Your Ref: OWPC20590
Our Ref: LU/257/18/HH
Please ask for:
Mr Z Denton

14th November 2018

Installation of crossover and hardstanding
21 Beaumont Park Littlehampton

SITE PLAN AS PROPOSED 1:200

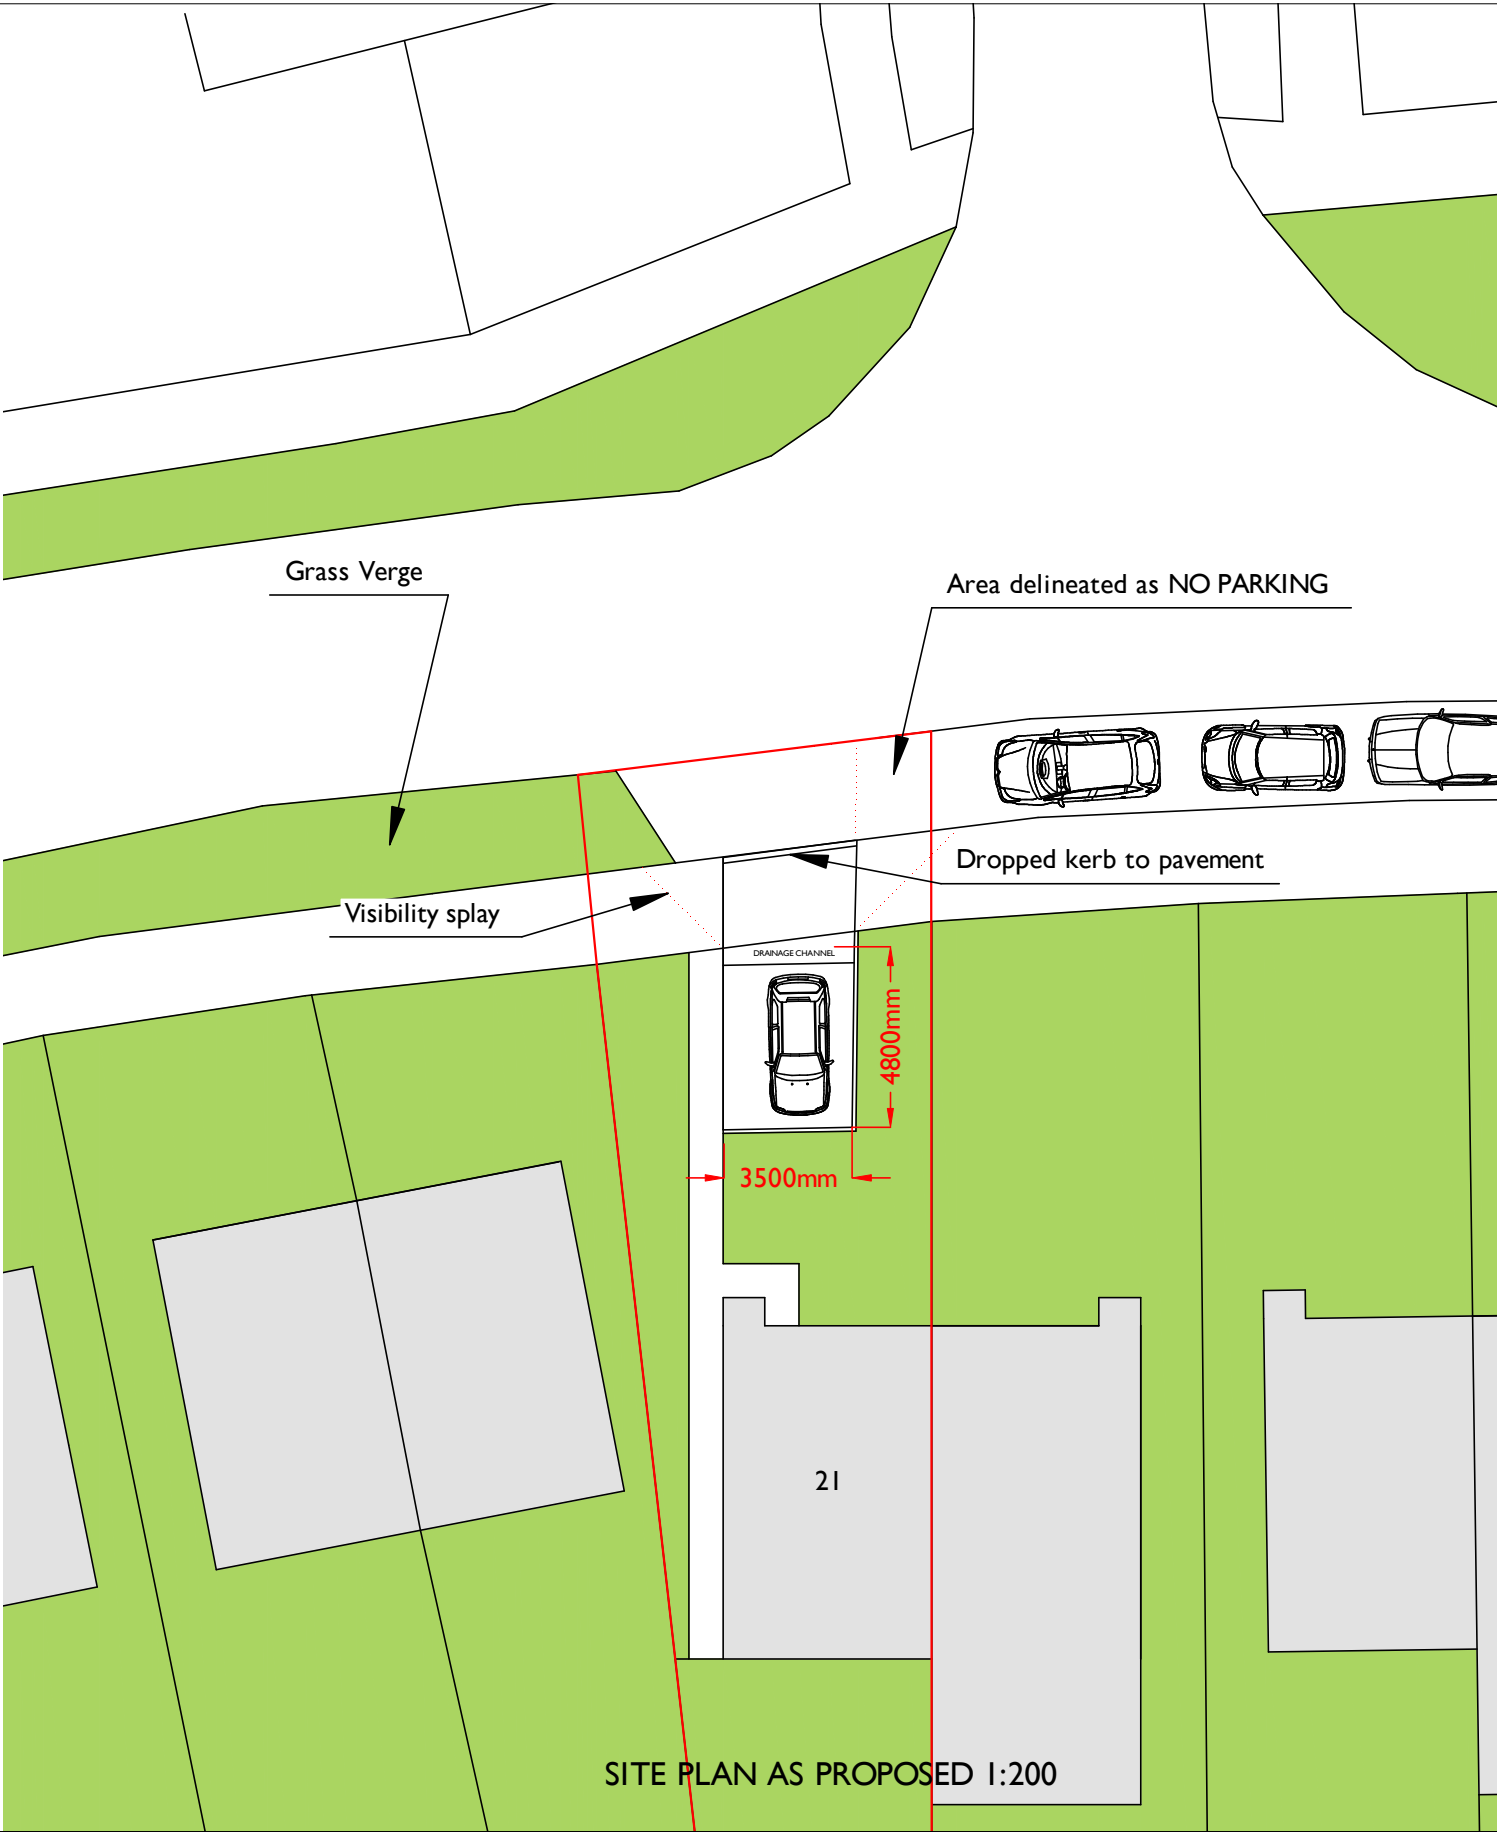
The Town Council's Planning and Transportation Committee considered this matter at its meeting held on Monday 12th November and object to the application. It was observed that the proposals impinged upon a layby on the highway and would result in the loss of public parking provision. The plans also conflicted with Section 3 of the County Council's Vehicle Crossing Guidance which states that they "do not permit the construction of vehicle accesses into parking laybys or dedicated parking areas". In the absence of any comments from West Sussex Highways, the Committee therefore objected to the application on the grounds that the proposals adversely affected highway safety and the convenience of road users.
